Appeal Decision

Appeal Ref: APP/T2350/W/25/3360729

1 Ferry Butts, Garstang Road, Chipping, Lancashire, PR3 2QJ

- The appeal is made under section 78 of the Town and Country Planning Act 1990 (as amended) against a refusal to grant planning permission.
 - The appeal is made by Mr Graham Gregson against the decision of Ribble Valley Borough Council.
 - The application reference is 3/2024/0793.
 - The development proposed is described as 'Change of use of a commercial building to domestic residential to extend an existing dwelling house'.
-

**TITLE**  
 PROPOSED FLOOR PLANS AND ELEVATIONS  
 SITE PLAN

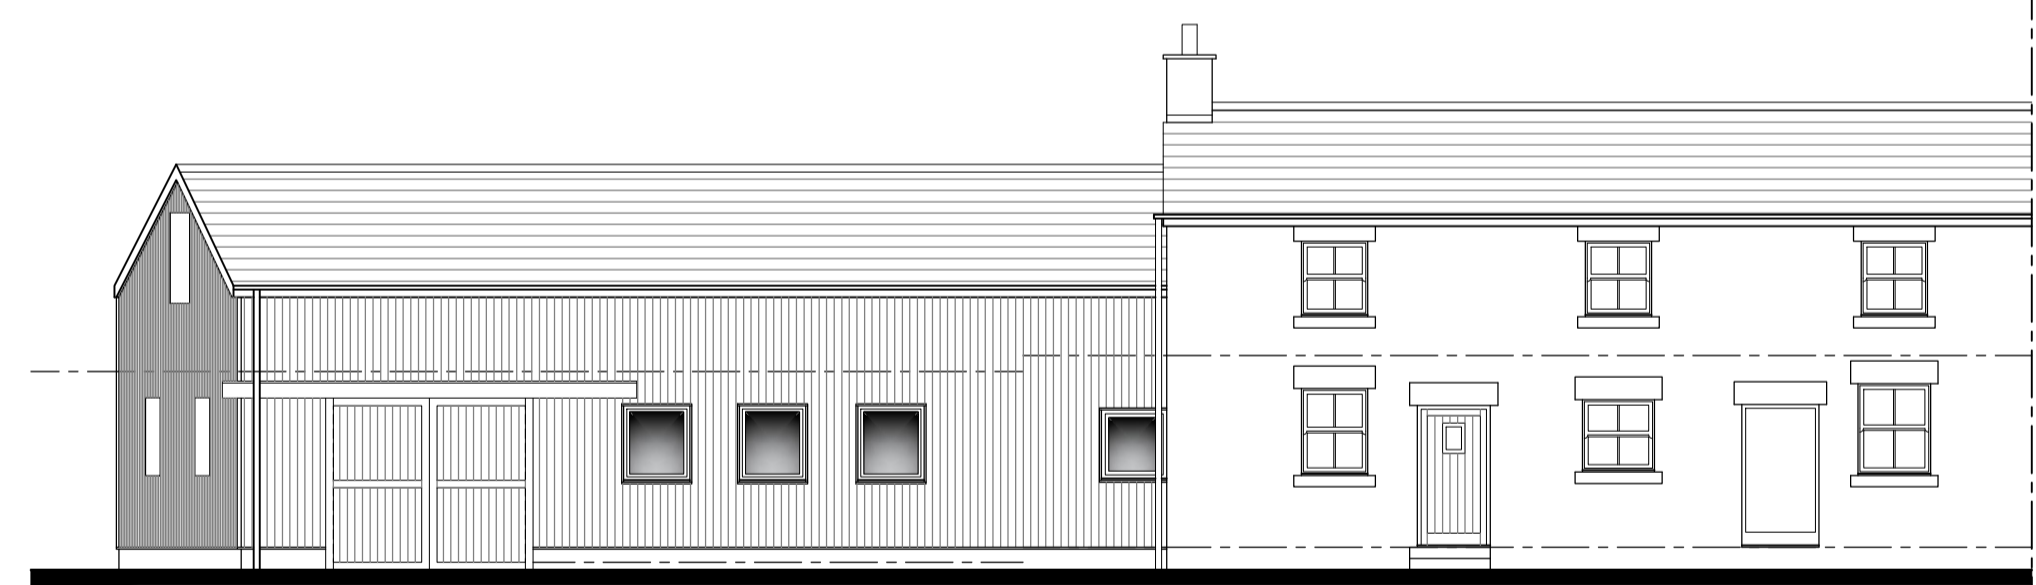
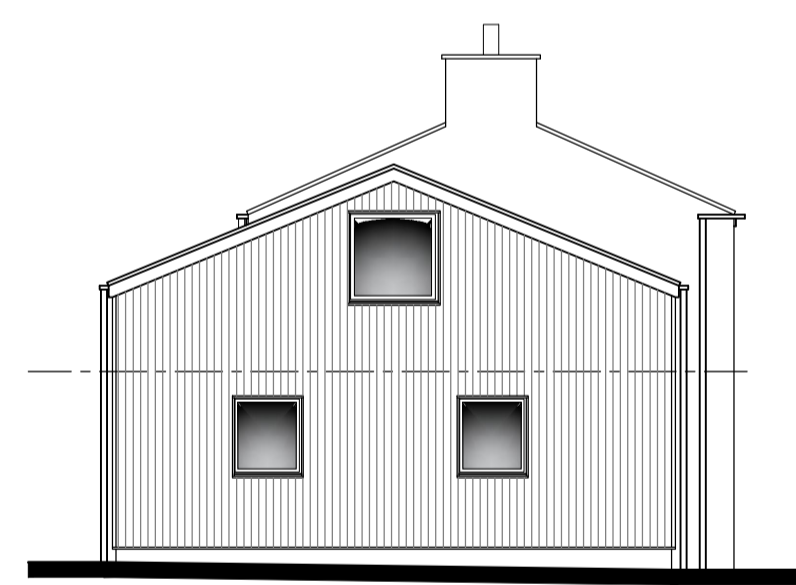
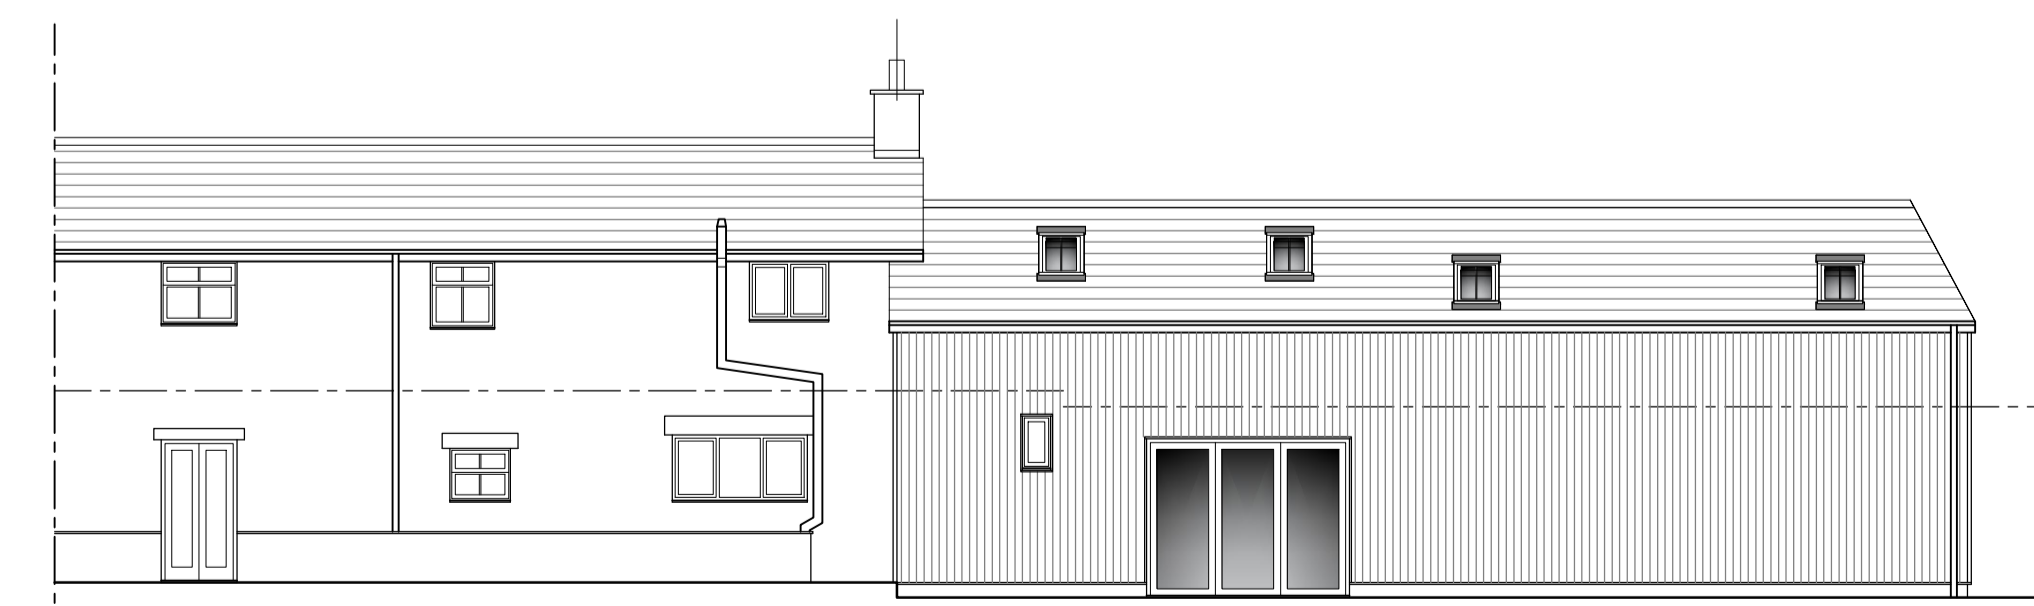
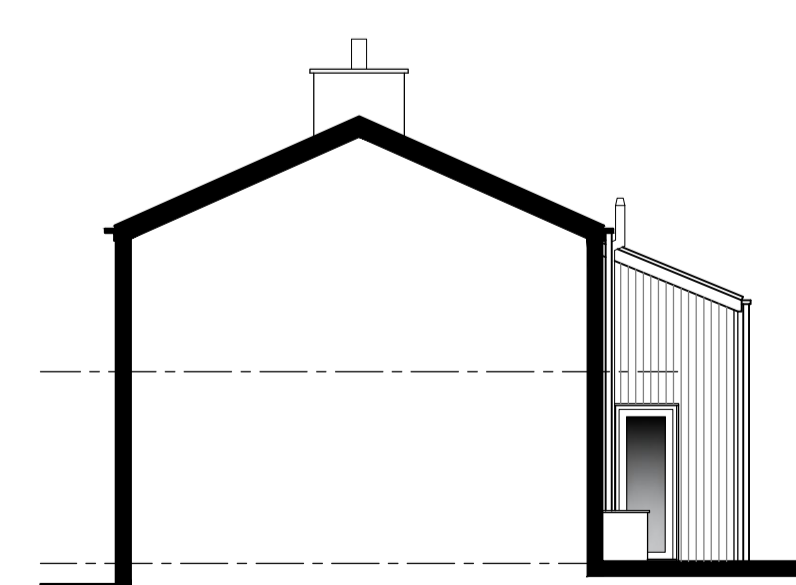
11. The proposal would include; the application of timber cladding over the existing rendered walls of the workshop, replacement of the existing green metal sheet roofing with natural slate, replacement hardwood garage doors, replacement of all other existing doors and windows using powder coated aluminium in a matt black

finish, the addition of a window to the gable end and doors to the rear, also using powder coated aluminium in a matt black finish, as well as four rooflights to the rear roof slope.

12. As a result of the proposed alterations, the scale and massing of the building itself would remain unchanged and so in this respect, it would continue to sit comfortably alongside these existing cottages, in the rolling pastoral farmland that surrounds the site. The replacement of existing doors and windows as proposed, and the addition of a small number of new openings, would not change the character or appearance of the existing building to any significant degree, particularly in public views. Slate appears to be a traditional building material in the locality, and its use would be consistent with the adjoining cottages.

13. The most significant change to the building would be the application of timber cladding to the existing walls. Initially, this would draw the eye and increase the visual prominence of the building in its setting, due to the newness of the timber. However, this would diminish as the timbers weathered, allowing the altered materials to assimilate into the landscape.

14. The use of timber as a building material is not uncommon in the area, with many farm buildings utilising the material. I accept that these are often detached farm buildings of an agricultural style. Nevertheless, it is a material common to the local area and while the finish to the existing building would change, it would not necessarily alter the building's character. It would still read as a workshop type building, distinct from the adjoining cottage, which is how it appears now, and so, the traditional built form and character of the adjoining cottage would not be undermined. Given the visual distinction between the workshop and the cottage, while the proposal would in effect significantly increase the domestic footprint of No. 1, it would not necessarily read as such externally, and so, the proposal would not appear as a discordant addition to this dwelling.
